Our Ref: Y/105/21/NMA

Non material amendment following the grant of Y/82/20/RES for amendments to the proposed site layout.

Land to the south of Ford Lane and East of North End Road Yapton BN18 0DS

Play Area (LAP 1) - Scale 1:100@A1

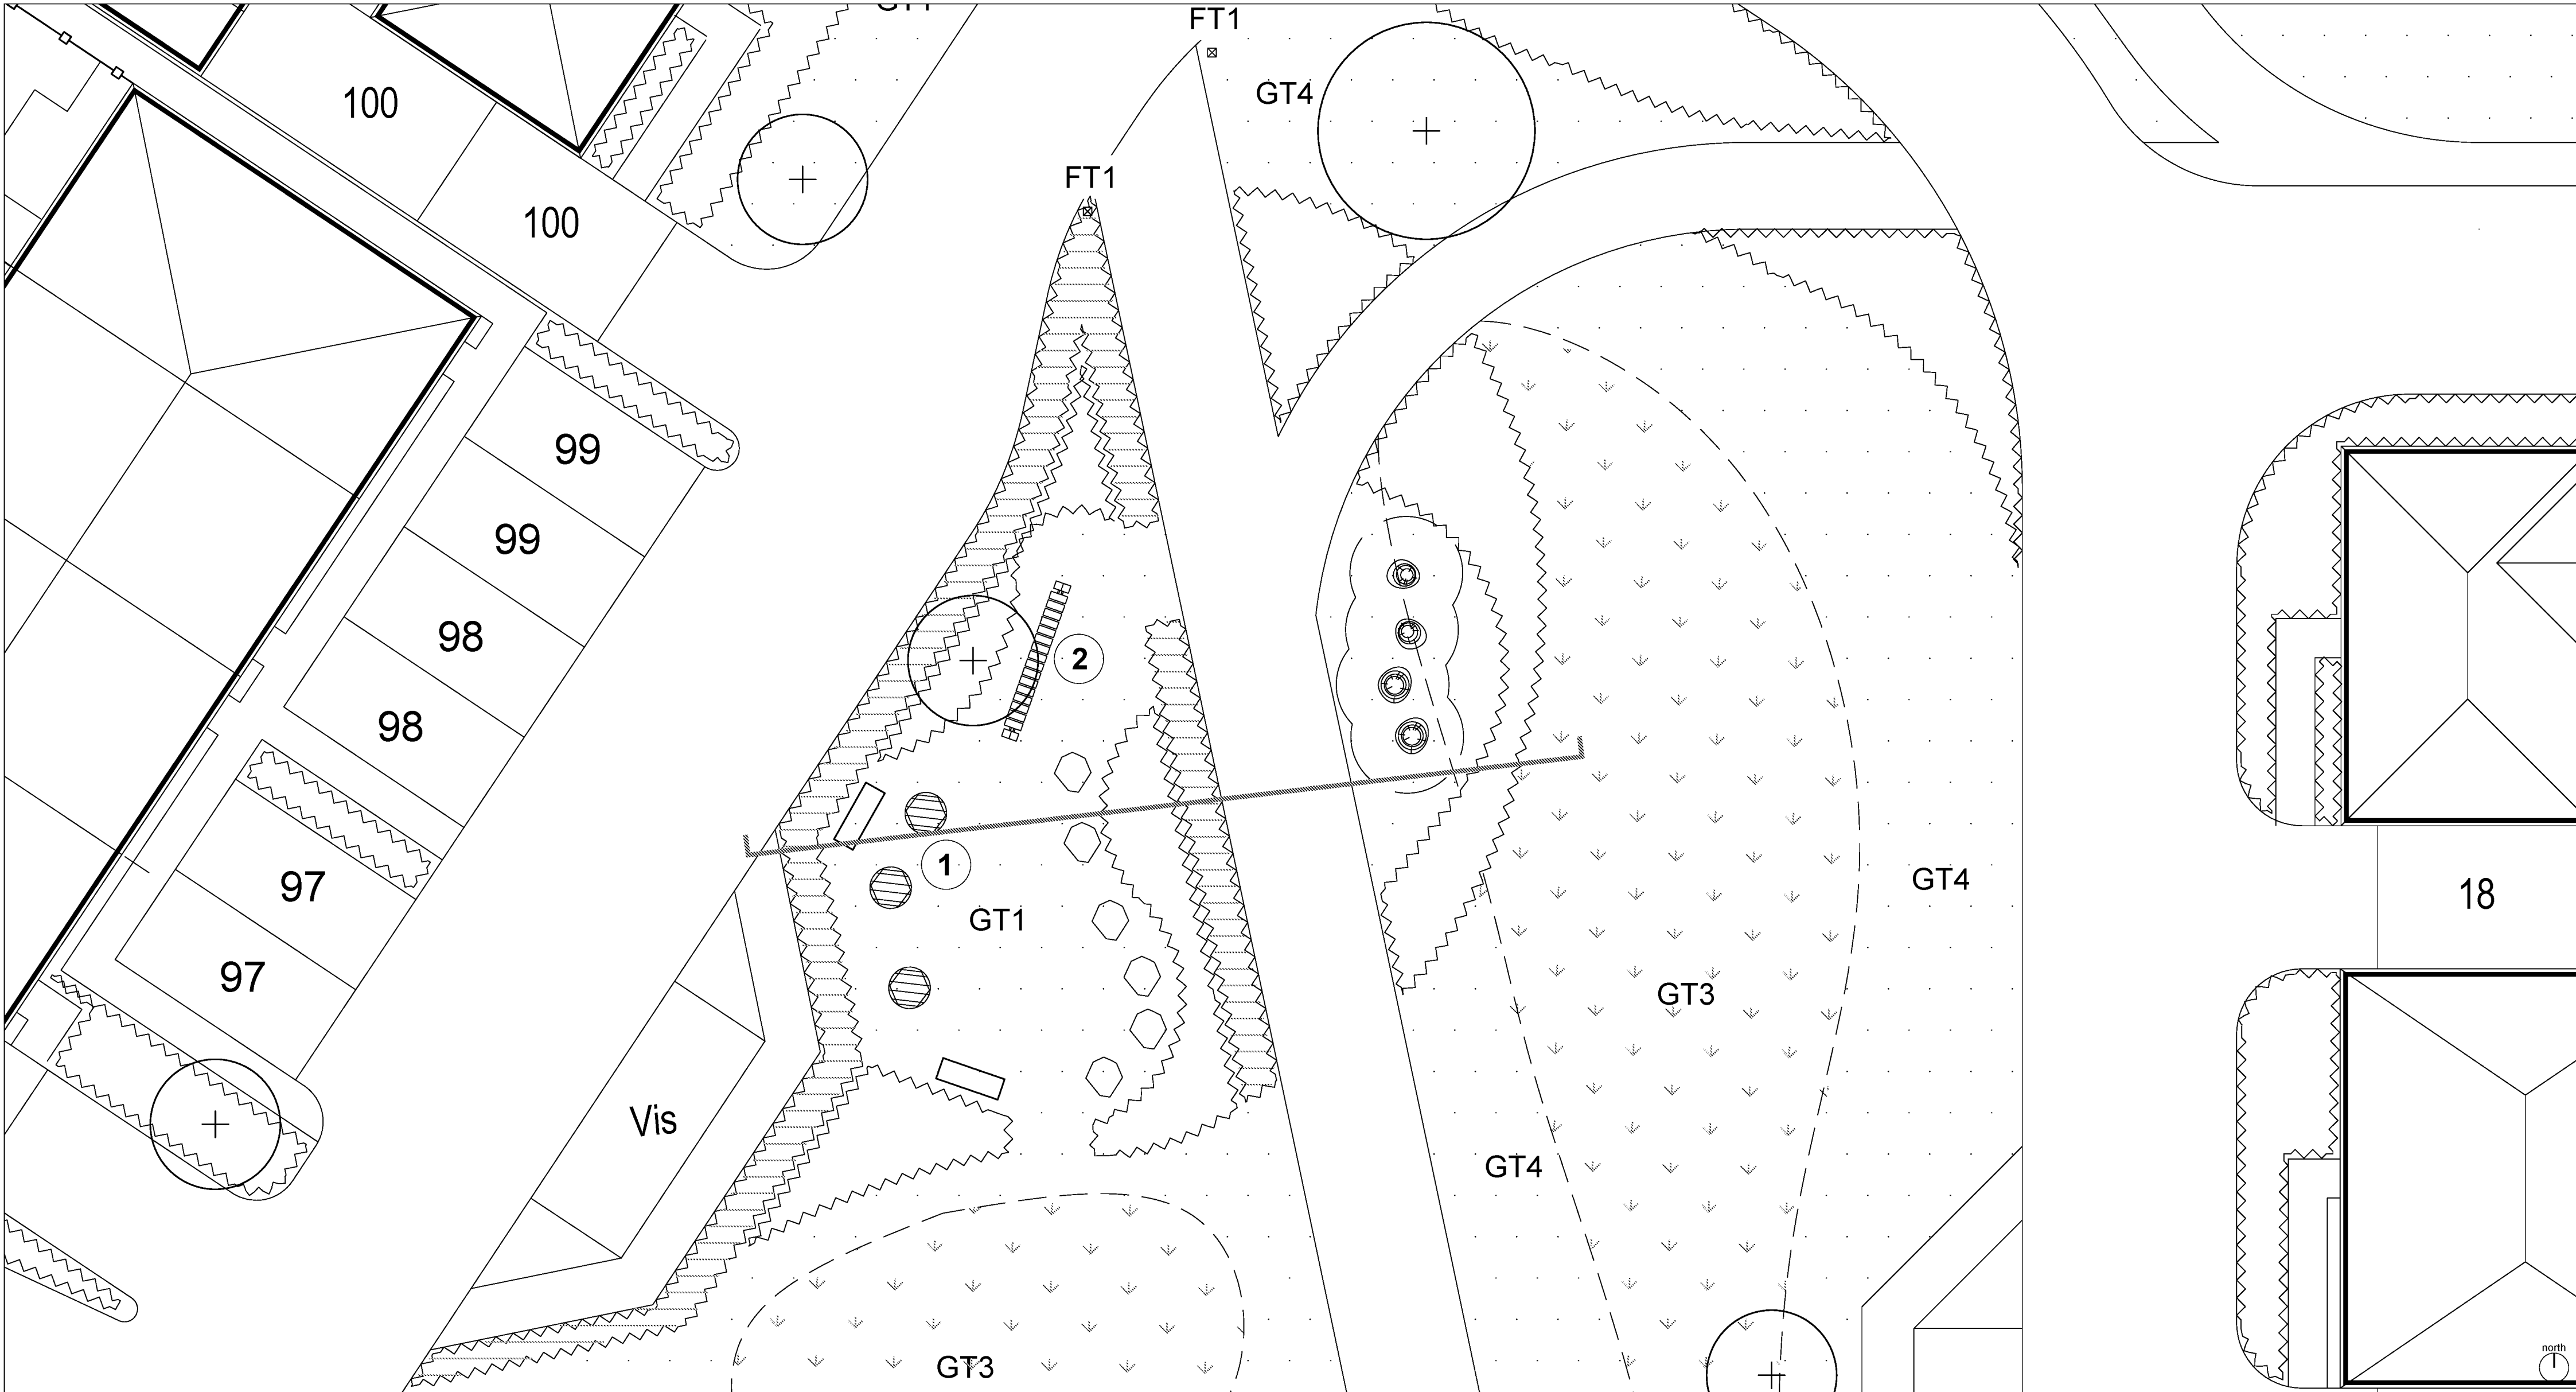
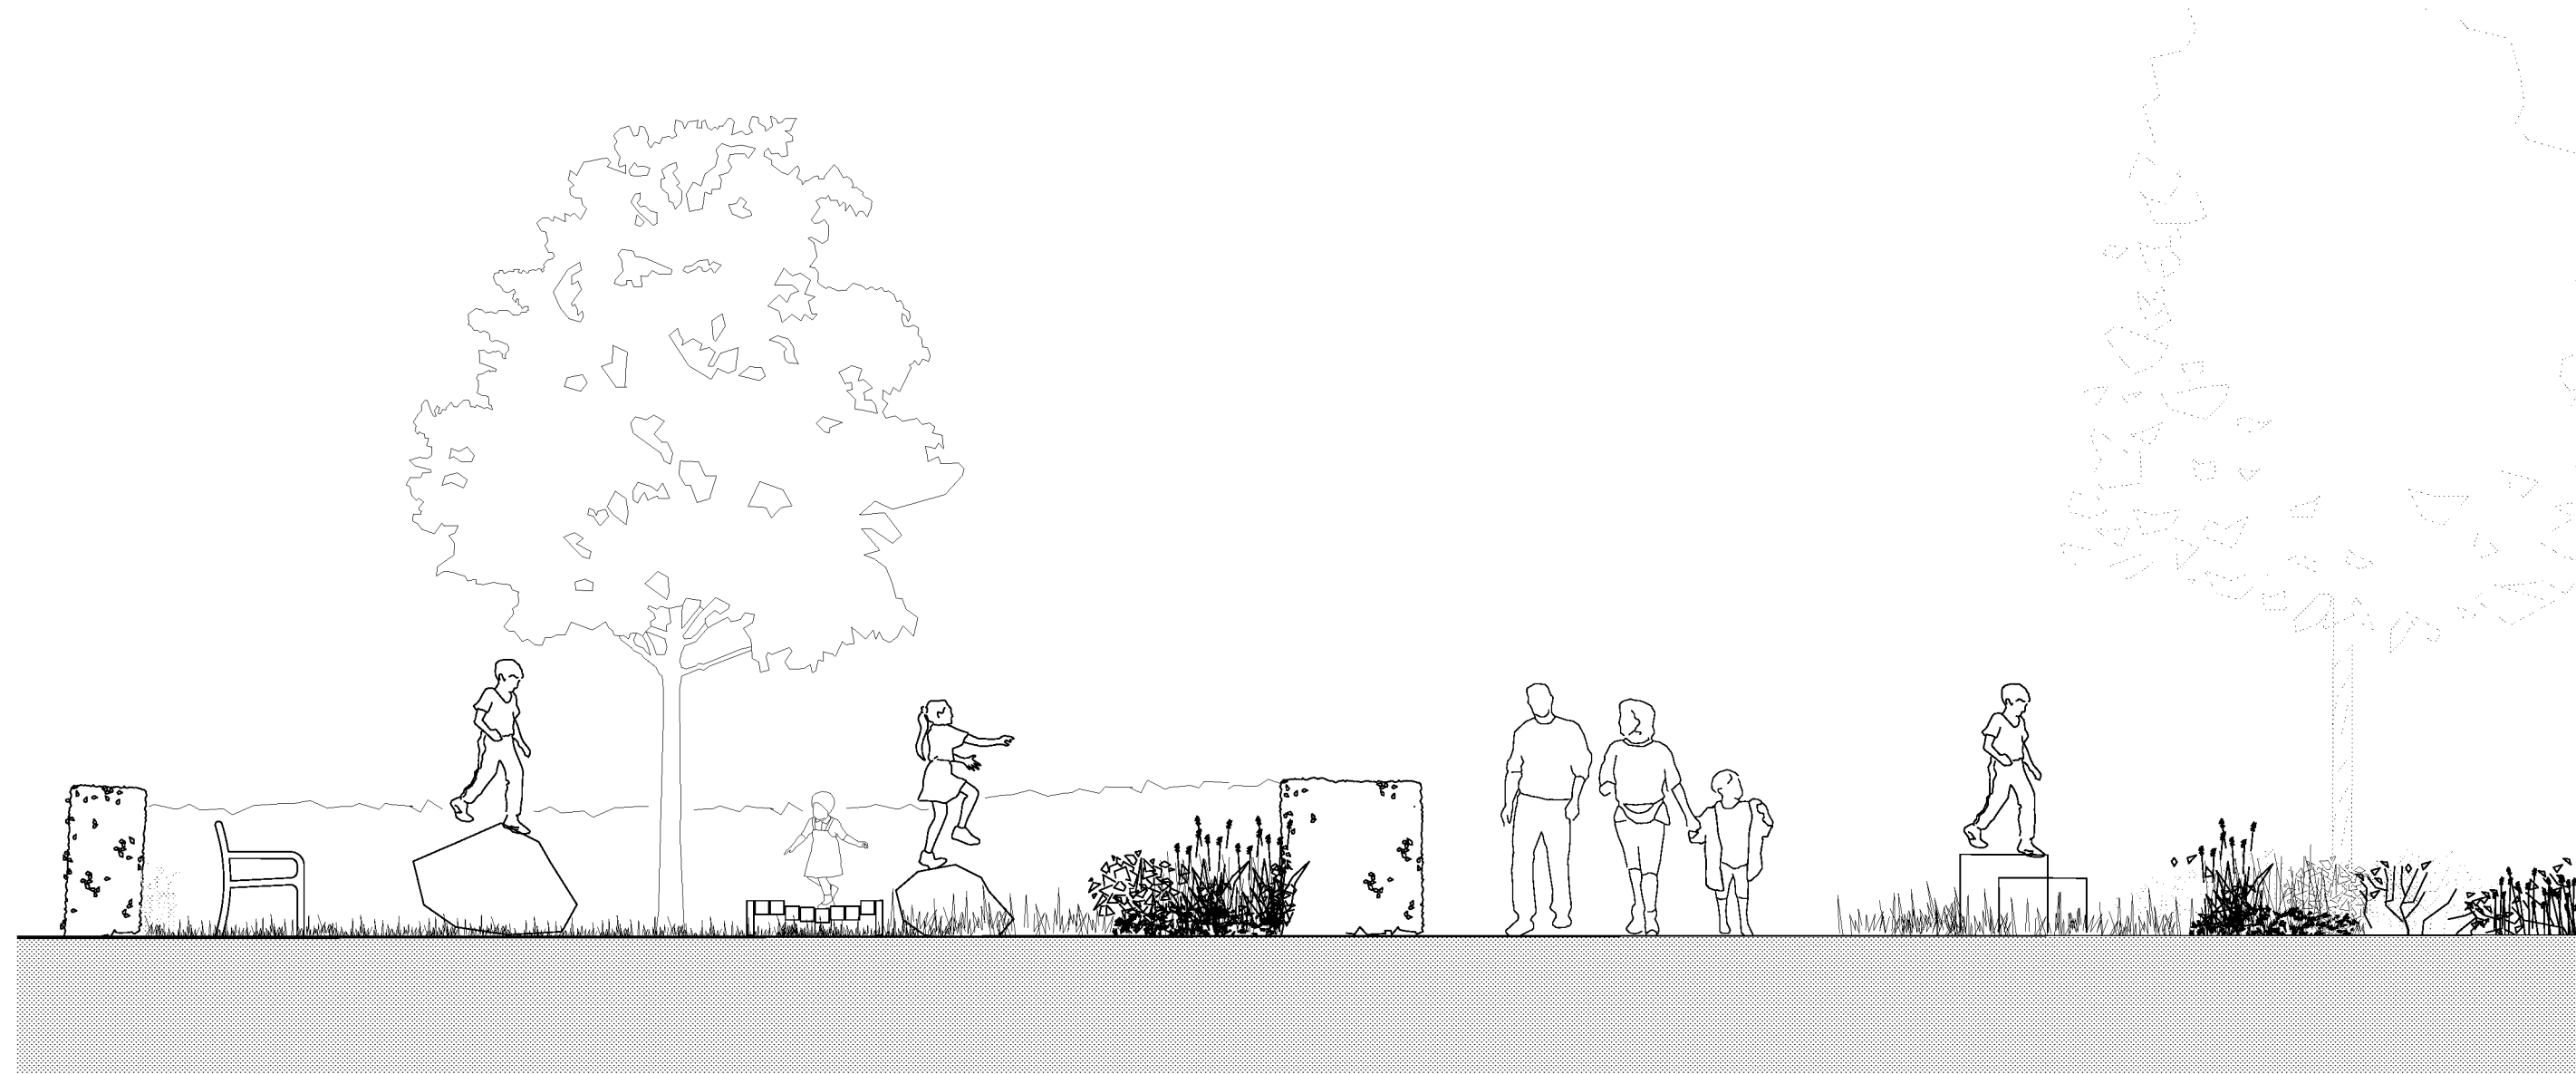
layout of the residential development and would require changes to the approved drainage strategy, which would result in the submission of a separate discharge of condition application. The re-location of the play area to the eastern side of the footpath in the southern area of open space would have a material effect upon the approved layout of the residential development in terms of the outlook from Plots 32 and 33; and the re-siting of the turning head near Plot 34 would compromise the visual appearance of the footway/cycleway and would compromise the safety of users of the footway/cycleway.

From the information submitted, I am not prepared to take the proposed re-location of the surface water drainage features and the play area to the eastern side of the footpath in the southern area of open space; or the re-siting of the turning head near Plot 34 as a Non-Material Minor Amendment to Reserved Matters approval (Y/82/20/RES) at Land South of Ford Lane and East of North End Road, Yapton.
